WEST SUSSEX COUNTY COUNCIL CONSULTATION

TO:	Arun District Council FAO: Maria Tomalova
FROM:	WSCC - Highways Authority
DATE:	18 February 2021
LOCATION:	Car park adjacent to The Royal Oak Public House, Chichester Road, Bognor Regis, PO21 5JF
SUBJECT:	BE/10/21/PL Retention perimeter post & rail fence to the back edge of road side verge with gated access from Chichester Road & North Bersted Street. This application may affect the setting of a listed building & the site is in CIL Zone 4 (Zero Rated) as other development.
DATE OF SITE VISIT:	N/A
RECOMMENDATION:	Advice
S106 CONTRIBUTION TOTAL:	N/A

Title
Block and Location Plans

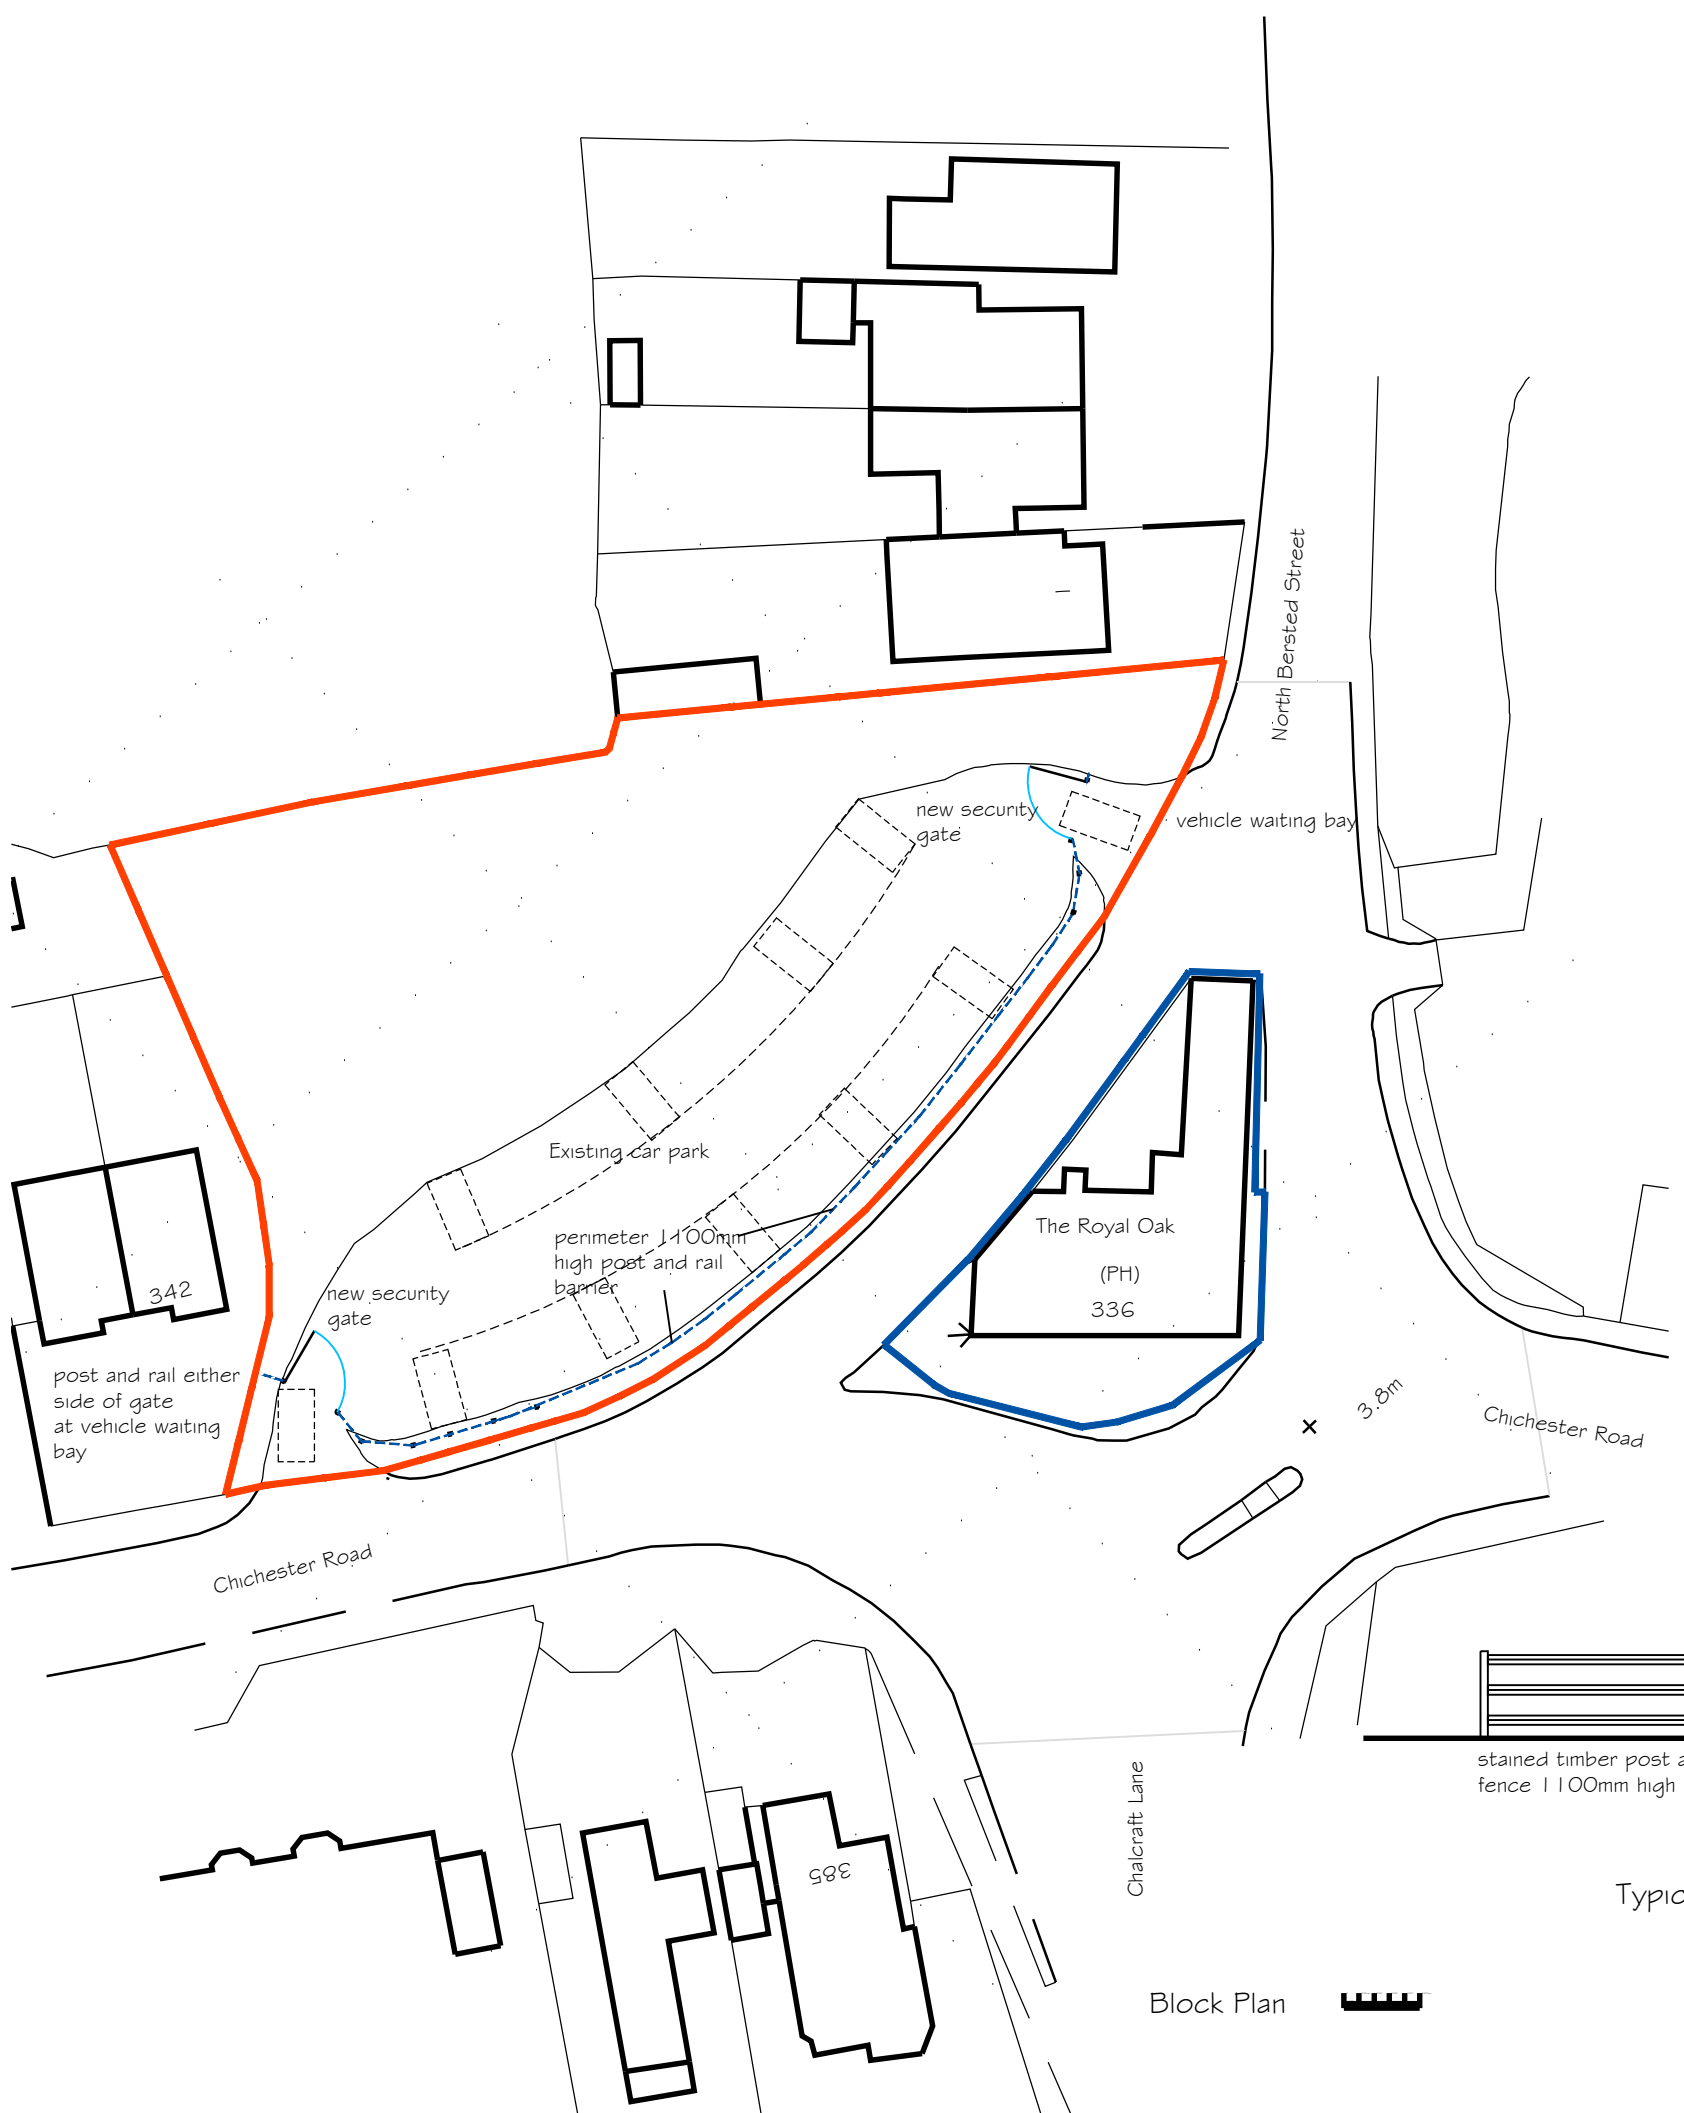
The applicant proposes a perimeter fence along the back edge of the roadside verge of Chichester Road and North Bersted Street. From inspection of local mapping, the fence line will not encroach into the maintained highway boundary.

In addition, the fence does not appear to obstruct vehicular visibility at the two existing accesses onto Chichester Road and North Bersted Street. Regarding the gated accesses, the gates are situated in locations whereby vehicles can pull in off the highway and wait whilst the gates are in operation.
